**Consultation Response from: KC Environmental Health (Pollution & Noise Control)**

**2024/90256 - Whitehall Service Station, Whitehall Road East, Birkenshaw, BD11 2EJ**

**Change of use from coin operated jet wash to attended hand car wash**

**Responding Date:  
24 June 2024**

Canopy Front/Rear Elevation

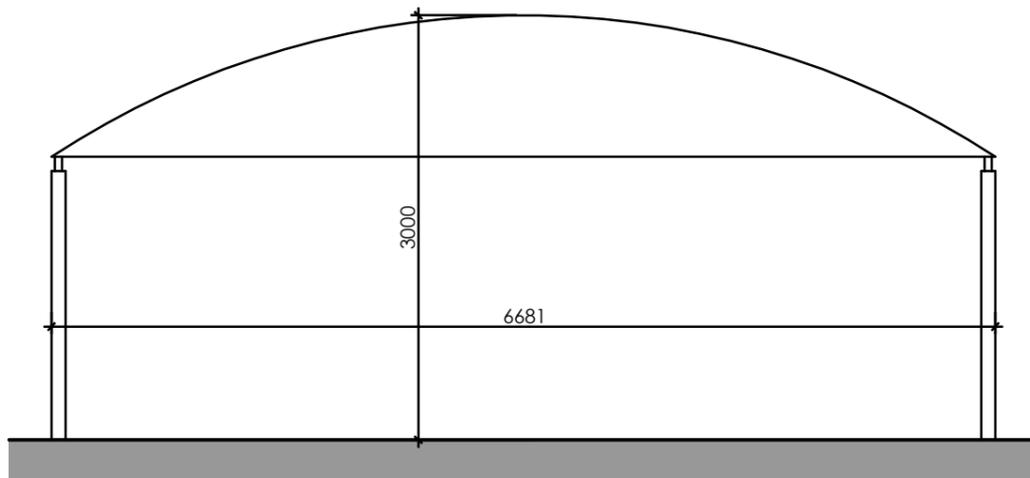
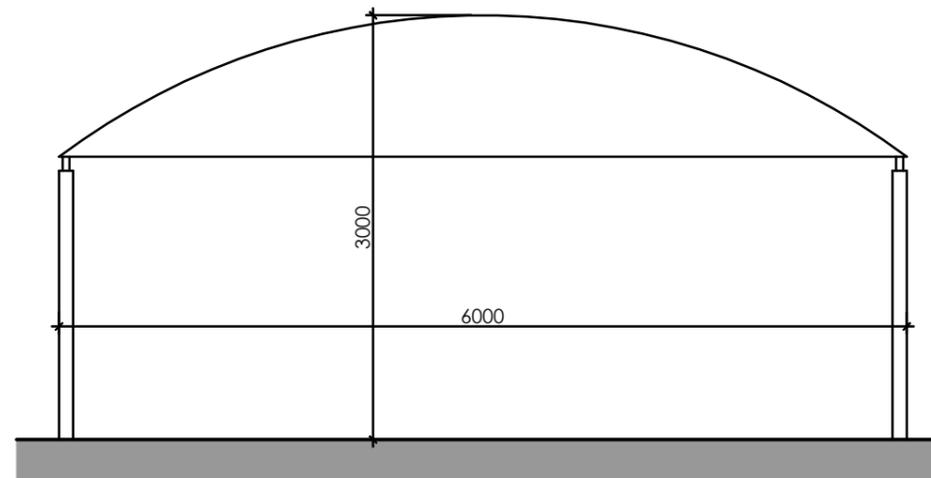
We note that there are to be 2x drying bays and it is assumed that part of the service will include vacuuming the interior. No information is given on whether vacuum cleaners will be used. The drying bays are covered but it is unclear if they are enclosed i.e. no gaps other than to the front. This will need to be clarified before we can comment further due to the potential for noise breakout to affect the amenity of neighbouring occupiers.
